# Memorandum

| <b>Subject</b>      | 1919 Maple Grove Road - Transportation Impact Assessment -<br>Addendum 1   |                   |                |

## Step 4 Submission (Analysis) – Circulation Comments & Response

A-001

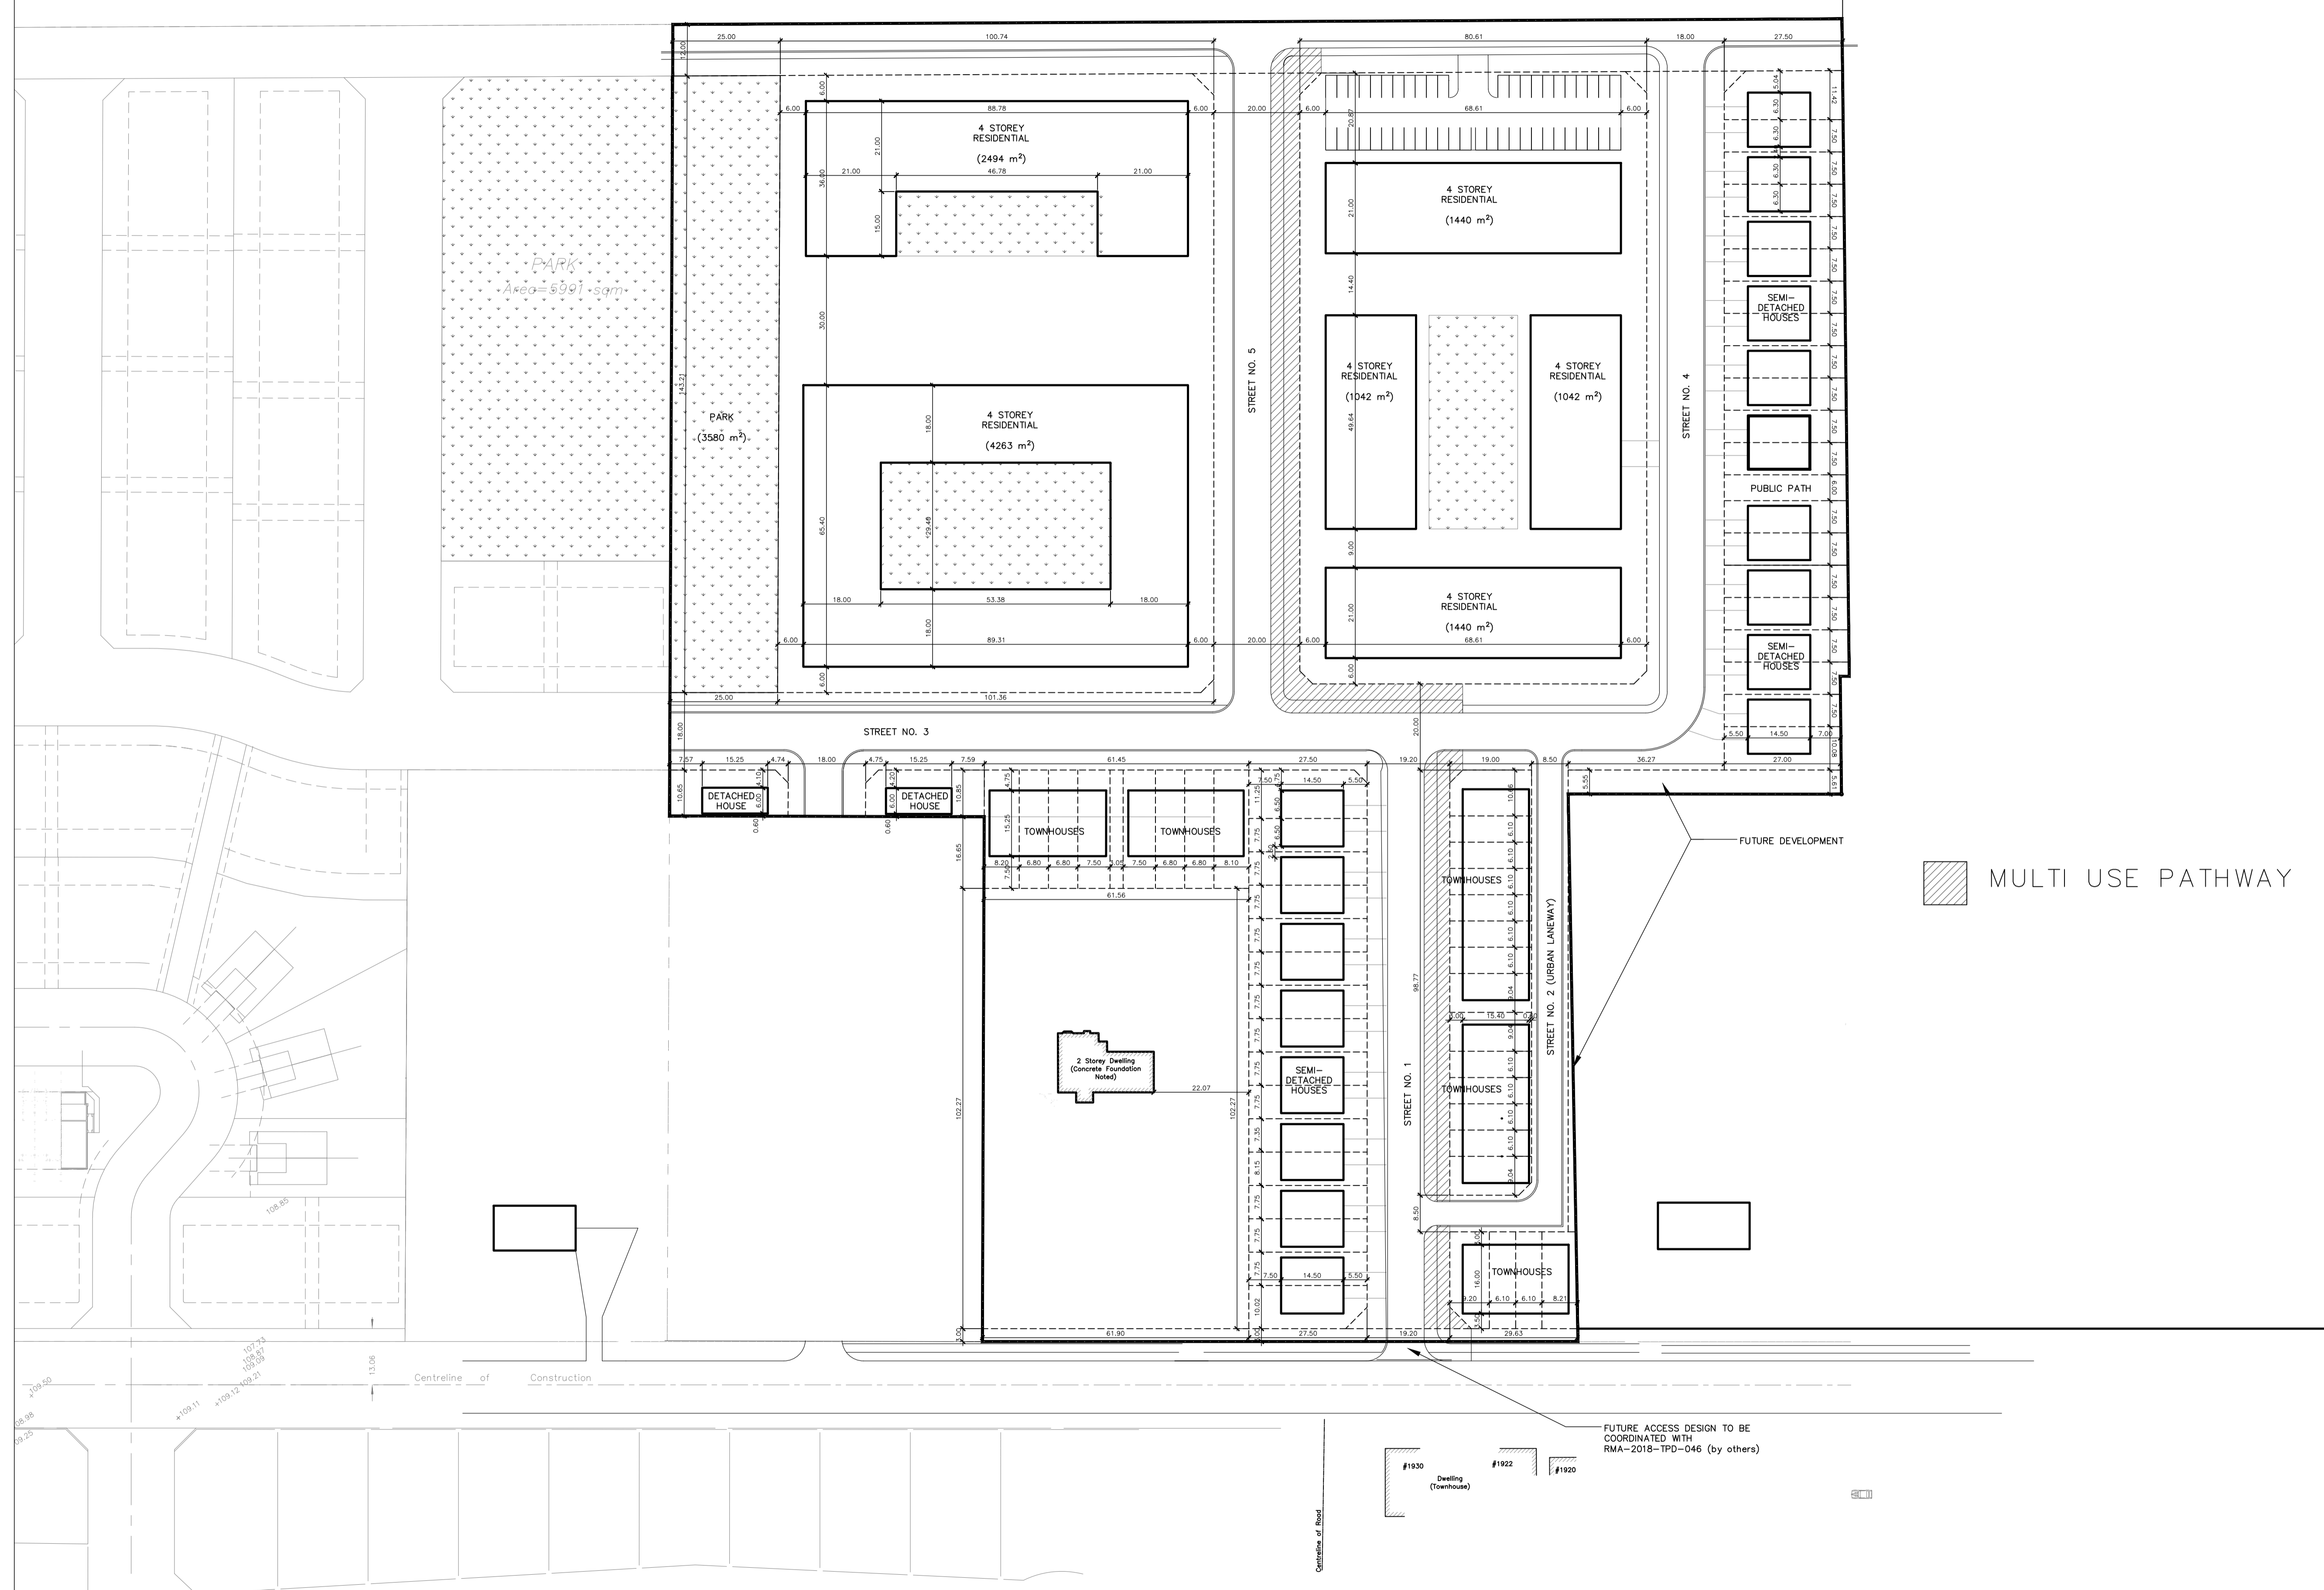
4. PM&S: indicate on the drawing at the access to MG that the design and PM&S to be constructed as per RMA form 1981 MG.

➤ **IBI Response: Acknowledged. A note has been added to the site plan, indicating "Future access design to be coordinated with RMA-2018-TPD-046 (by others)".**
